Our Reference: 21-0379nmc1

Re: Review of Submissions—Pymble Ladies' College, Grey House Precinct (SSD-17424905)

Pymble Ladies College, Grey House Precinct Project

Response to Heritage Related Submissions

NORTH / SOUTH ELEVATION

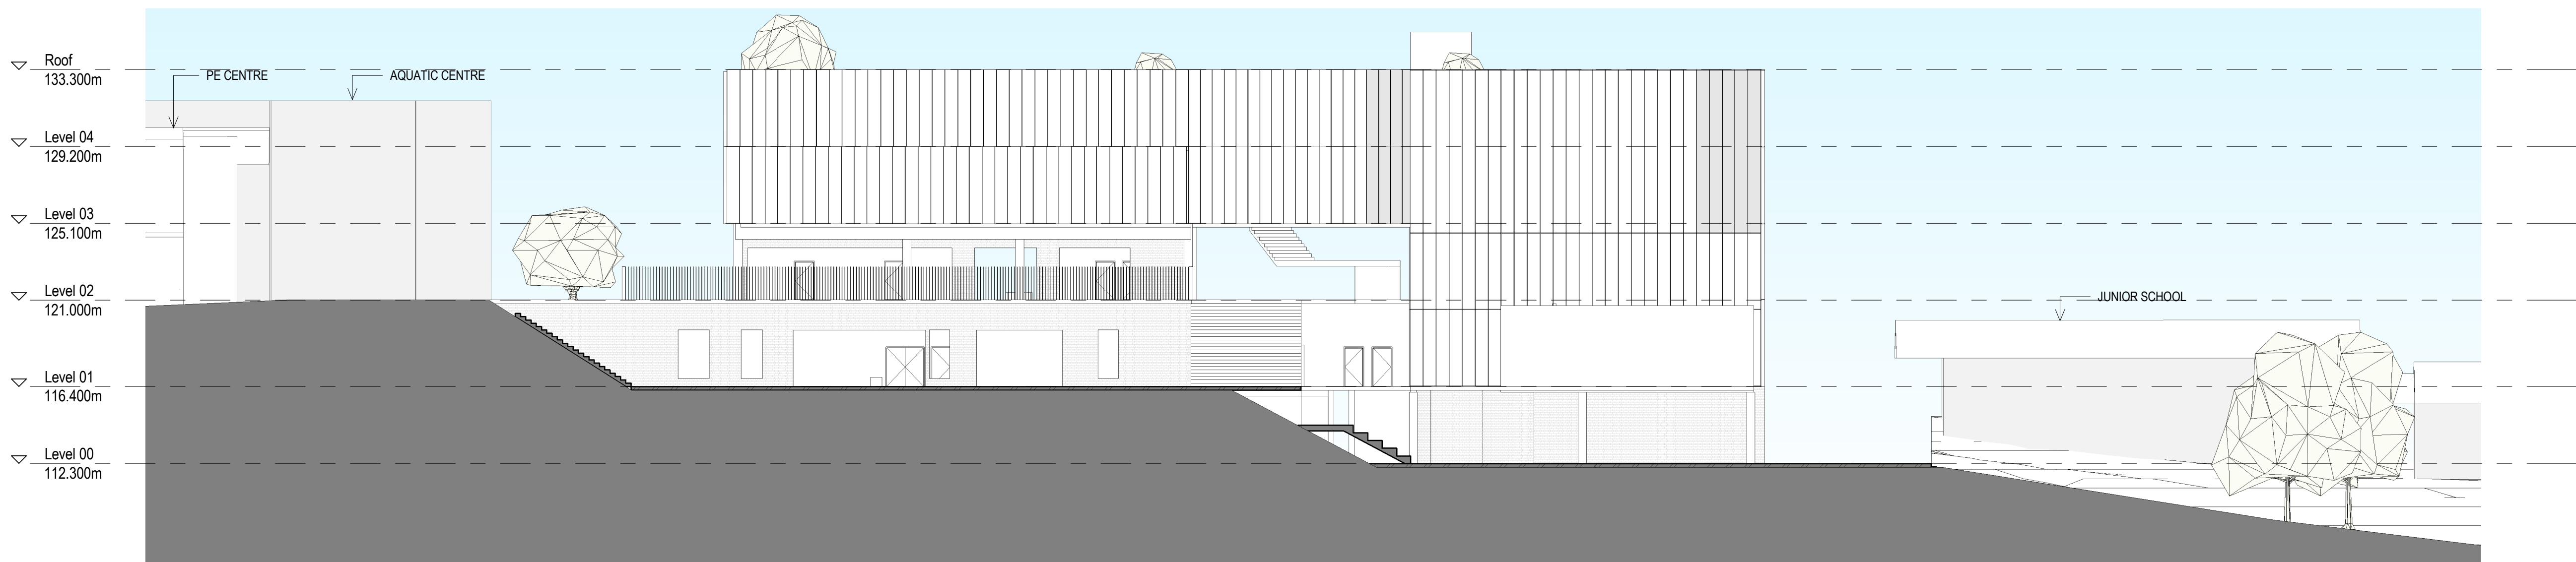
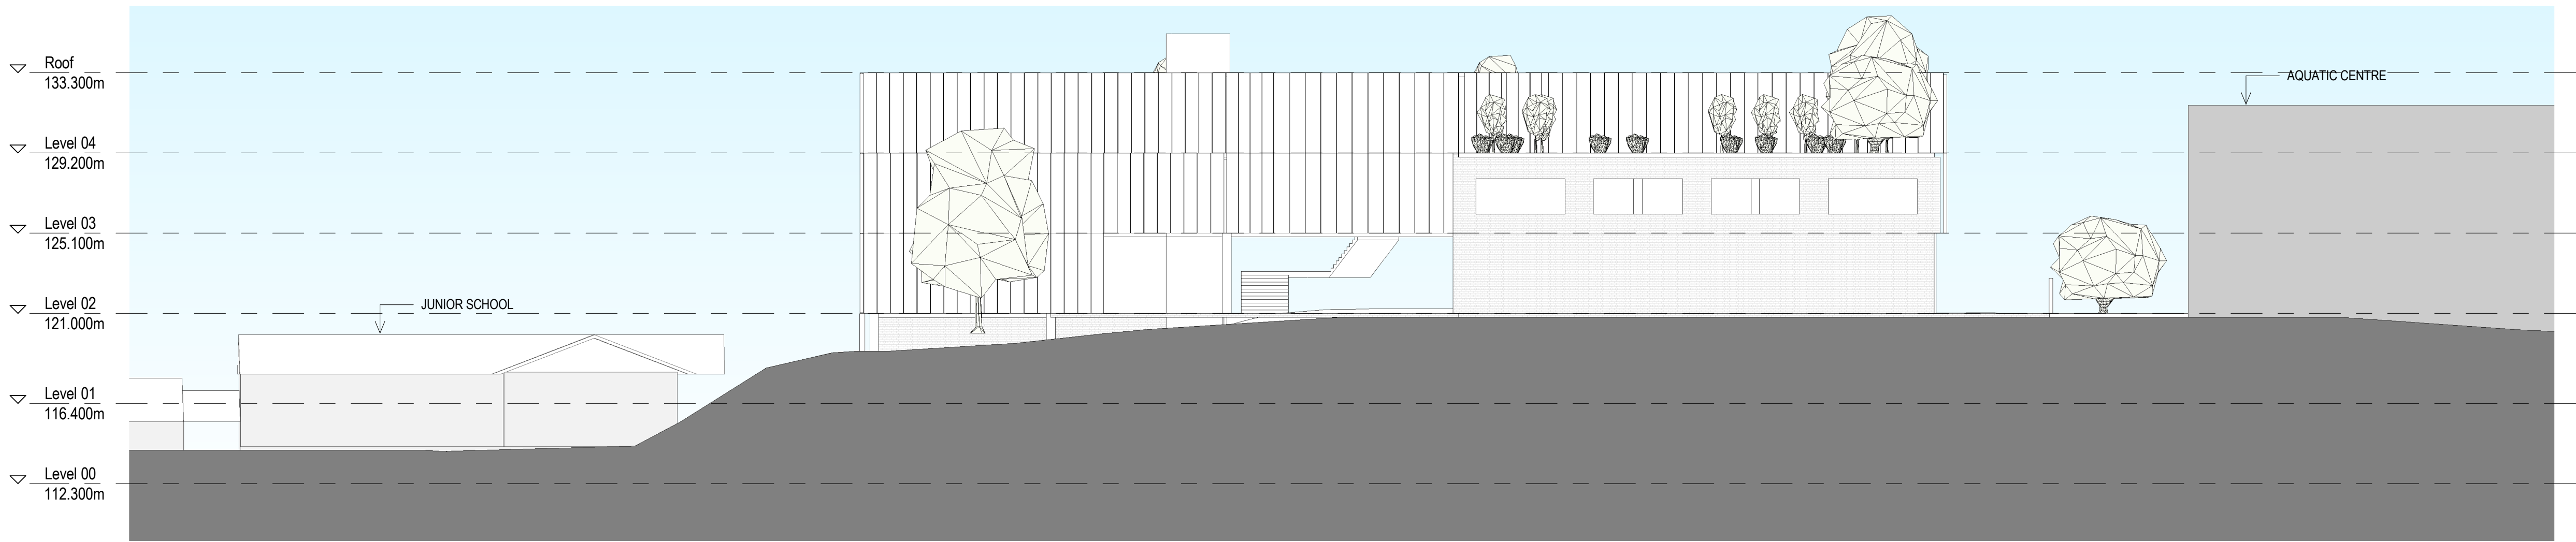
82 Ian King Pymble	<p>Extract:</p> <p>"The five-storey bulk of the proposed structure is out of keeping with the heritage streetscape of the area. Despite references to it being three storeys on the uphill side, it will be a five storey building when looked at from the east/south-east and will be very visible from Pymble Avenue. Architecturally, it will be out of keeping with the chapel which currently forms the skyline. My suggestion would be reduction of the height to 4 storeys for the easternmost half so that it steps up the hill and will then be less blocky. It would then probably have a benefit of more sunlight for the neighbouring properties. These issues are raised in Table 31</p>

Number/ Objector/ Location	Submission Extract/Response
	<p>of the Government Architect Response to the proposed structure and are not satisfactorily addressed by the proposers.”</p> <p>RESPONSE</p> <p>Refer to the Response to Submissions Nos.1, 2 and 19.</p>
<p>83 Leah Dabron Surry Hills (submitted twice)</p>	<p>Extract from SJB letter:</p> <p>5.0 Impact upon Pymble Avenue Heritage Conservation Area (HCA)</p> <p>The proposed five (5) storey building is inconsistent with Section B, Part 19 Heritage Conservation Areas of the Ku-ring-gai Development Control Plan (KDCP) 2021. Specifically, control 19F.1 Local Character and Streetscape, which requires development in the vicinity of a HCA to have regard to the form of the existing building or buildings, including height, roofline, setbacks and building alignment. Dwellings within the HCA are two (2) storeys in scale and predominantly federation to mid-late twentieth century period. The proposed five (5) storey Grey House Building is of a bulk, scale and design that dwarfs existing dwellings and detracts from the heritage values and significance of the HCA. The proposed scale and overall height of the building is considered completely out of context which is amplified by the fact it will be seen from Pymble Avenue, including the dwellings located within the Pymble Avenue HCA.</p> <p>RESPONSE</p> <p>Refer to the Response to Submission No.2.</p>
